Road Safety Audit Report

Incorporating
Stage 1/2 Completion of Detail Design;
Design Organisation Response to items raised.

Proposed Works to existing Public Footpaths through Meadow Gardens, North End Road Yapton

Report Title:	Stage 1/2 Road Safety Audit
Date:	March 2021
Document reference and revision:	RSA-20-193-3
Prepared by:	Fenley Road Safety Limited
On behalf of the Overseeing Organisation:	West Sussex County Council
Design Organisation:	i-Transport LLP
Project Sponsor:	Redrow Homes Ltd

Drawing Title
Sections through public right of way footpath 357

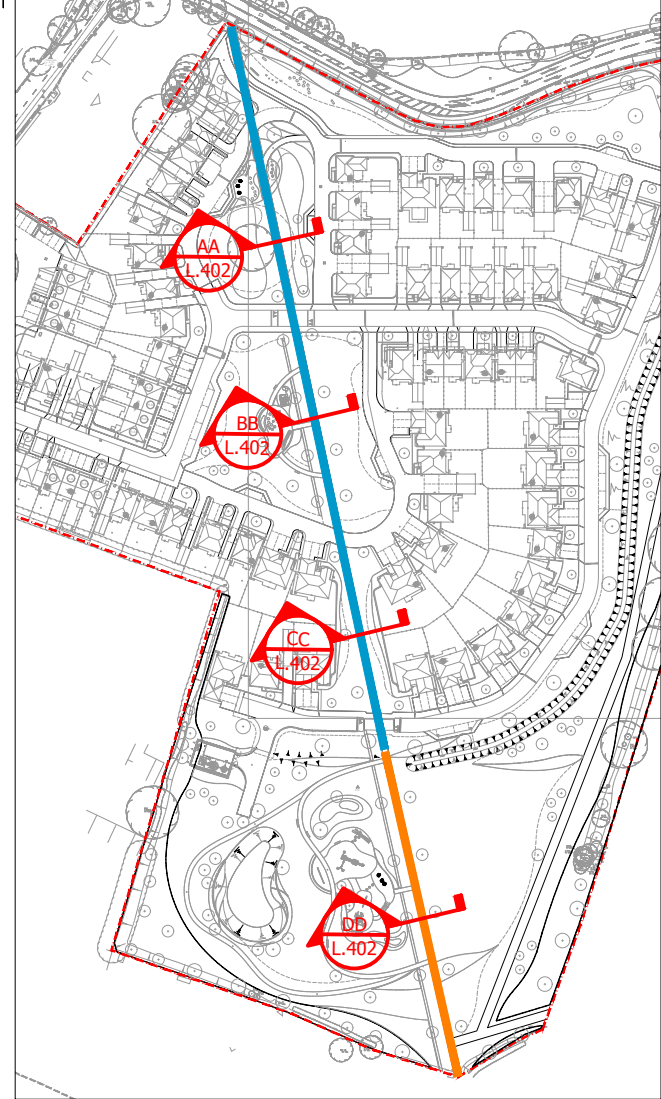
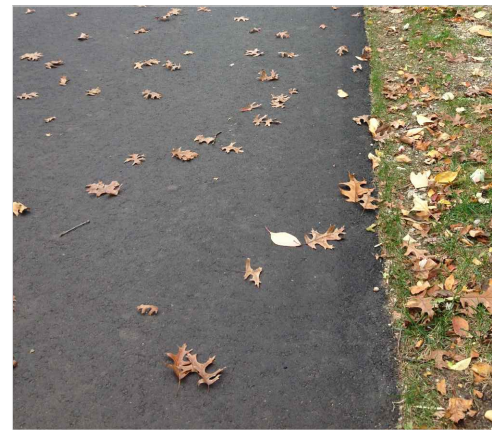
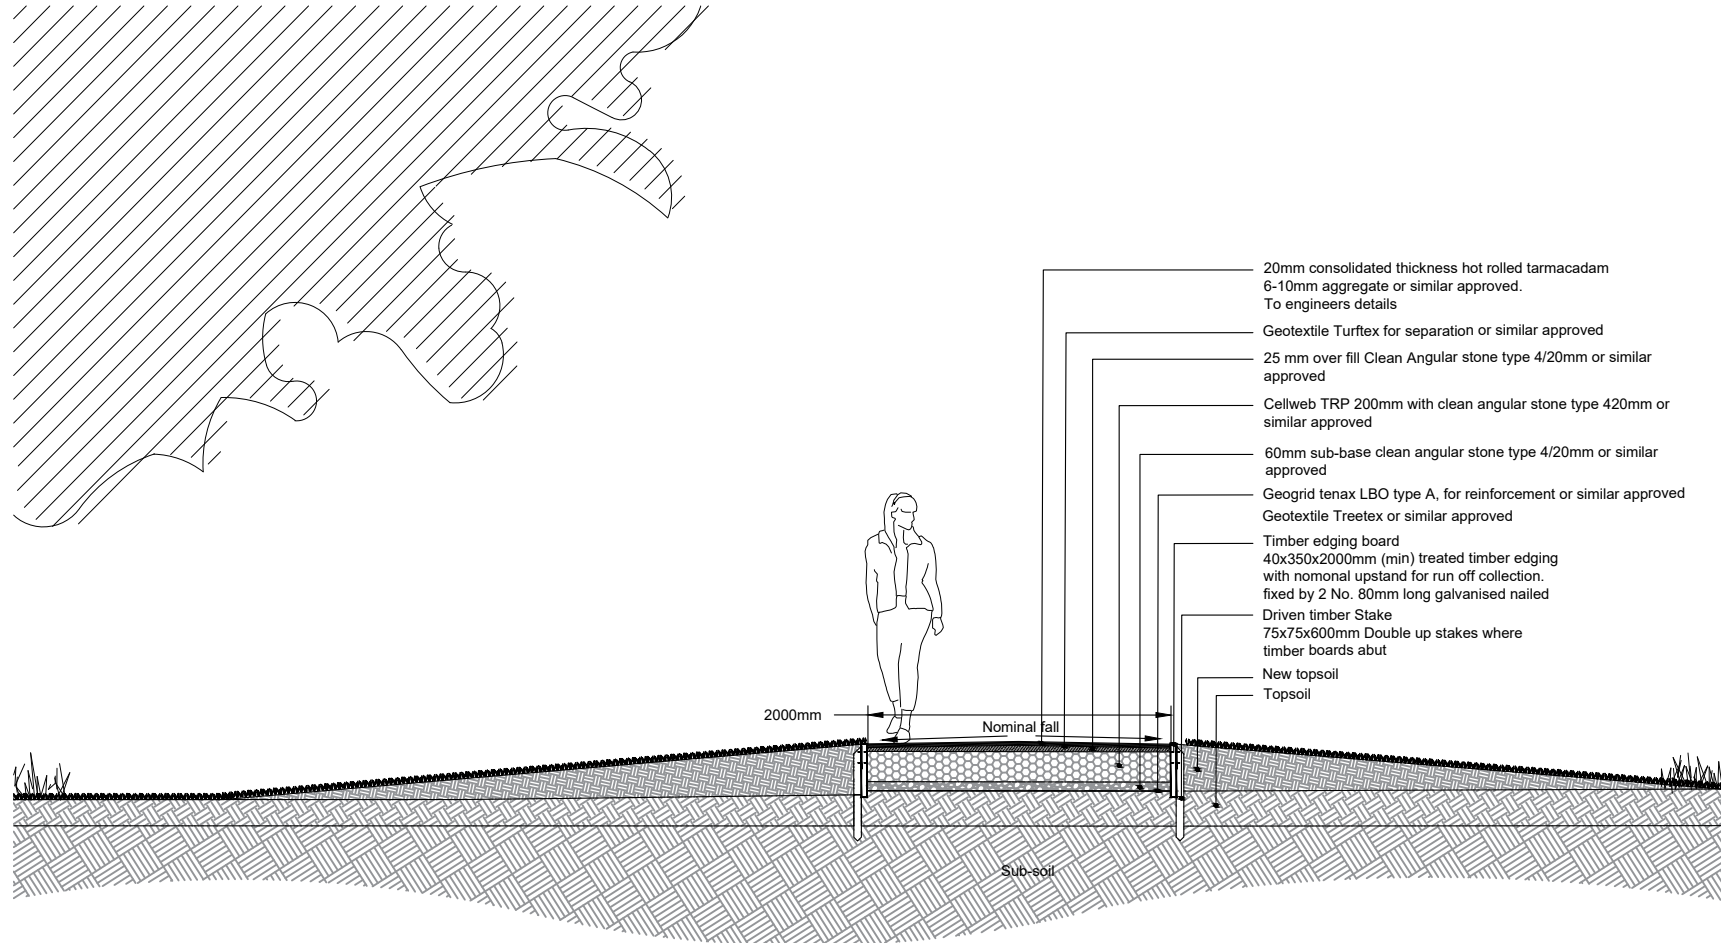
B.1	LOCAL ALIGNMENT
	<i>No Road Safety Concerns regarding LOCAL ALIGNMENT have been raised at this stage</i>
B.2	GENERAL
B.2.1	PROBLEM
Location:	Northern section of PROW 357
Summary:	Scheme encourages cyclists to travel down a steep set of steps
Acc Type:	Cyclist fall and vehicle cyclist collision
Footpath 357 forms a public right of way that currently passes between the southeast and northwest extents of a field meeting footpaths 358 and 359 to southeast and Ford Lane to the northwest. The field is set above the level of the Ford Lane carriageway with access gained via a set of 6 uneven concrete slab steps with a wooden handrail, up the grass embankment. The Audit Brief that has been supplied to provide sufficient information to undertake this Stage 1/2 Road Safety Audit, states that the connections between the site and existing rights of way which are outside the redline boundary, are outside the scope of the Audit and that the current proposals are to provide footpaths within the application site. However, it is understood that there are aspirations to upgrade footpath 357 to a footway cycleway. Whilst the existing connection between the footpath and Ford Lane allows pedestrian to walk up steps that are currently substandard and result in a pedestrian stepping straight onto the carriageway, the use of the connection by cyclists would result in the requirement for a bicycle to be transported up / down steps and could lead to cyclist falling and a personal injury or falling into the Ford Lane carriageway into the path of a vehicle resulting in a vehicle cyclist collision.

RECOMMENDATION:	
It is recommended that the northern most section of footpath 357 is reduced to 2 metres and measures are provided to deter use by cyclists with landscaping / planting provided either side of the staggered barriers to ensure that cyclists cannot bypass the measures.	
Location Plan:

Accepted – the width of the footway has been narrowed to 2m and landscaping features have been identified on either side of the path/barrier to prevent by-passing of the infrastructure. The revised design is presented in drawing ITB14679-GA-002 Rev C.
